Charlotte Storm Water
600 East Fourth Street
Charlotte, N C 28202-2844
OFFC: 704 . 336 . RAIN
FAX: 704 . 336 . 6586

Rezoning Petition Review

Date of Review: July 10, 2008 (**Revised October 23, 2008**)

Rezoning Petition #: 08-126

**SITE PLAN**  
 1"=10'-0"

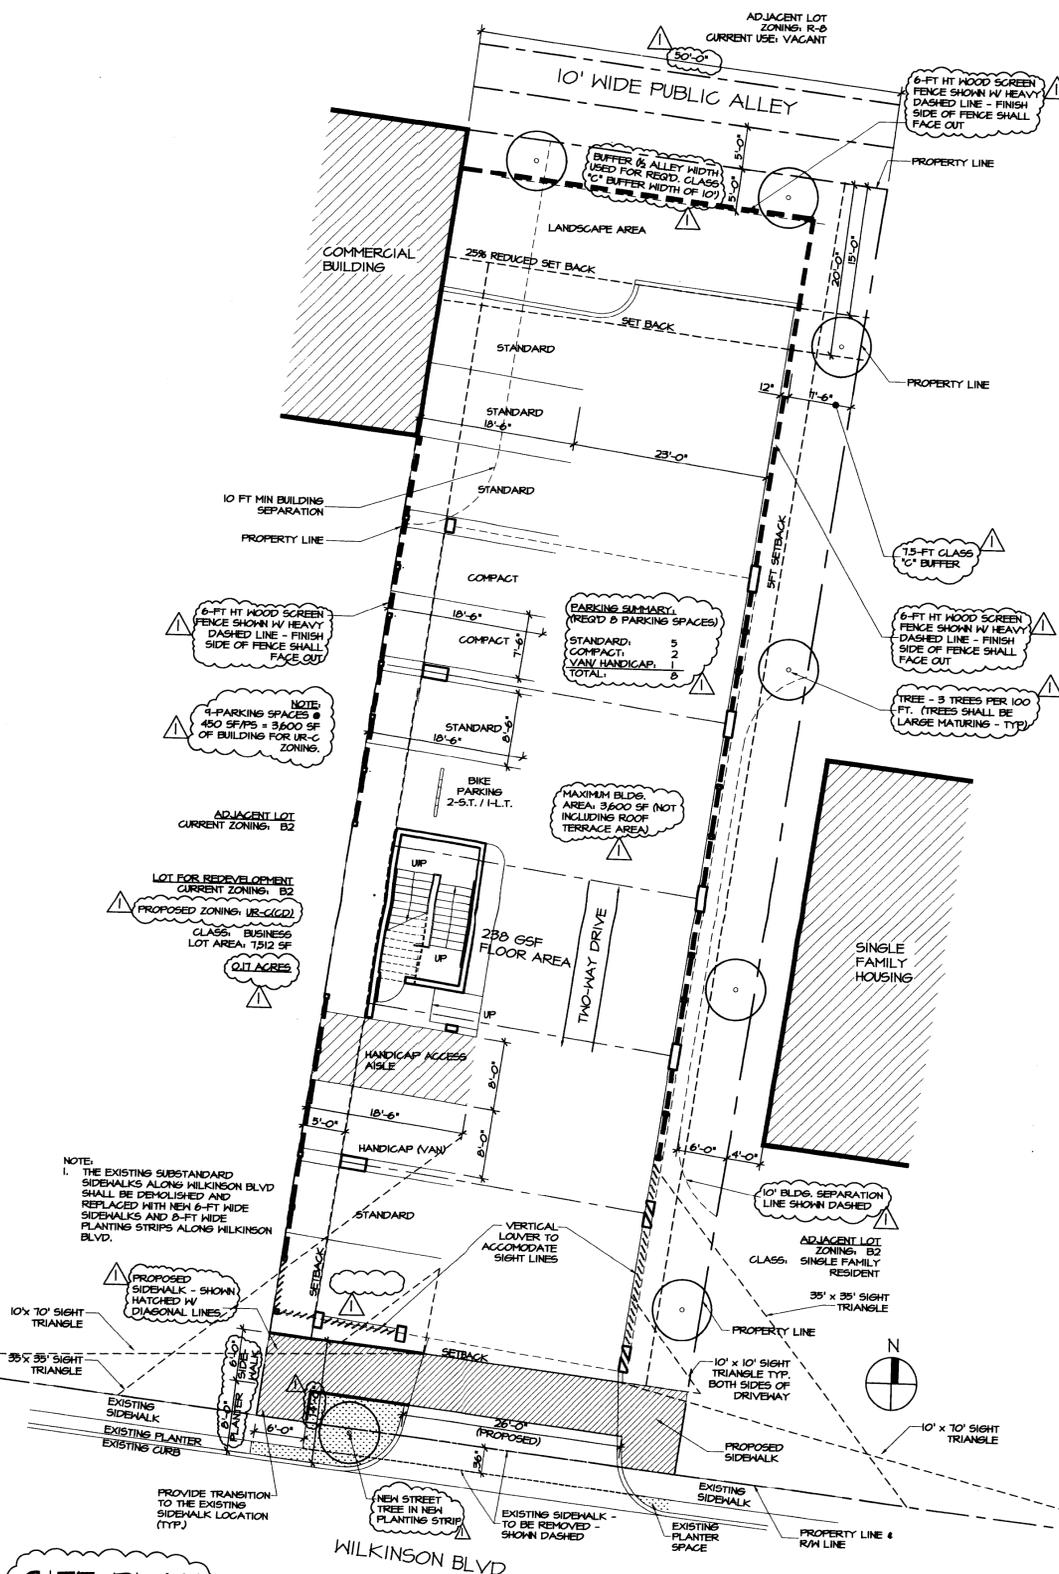
Concerning Storm Water: **Add the following note**

The petitioner shall comply with the Charlotte City Council approved and adopted Post Construction Controls Ordinance.

No additional recommendations are needed at this time.
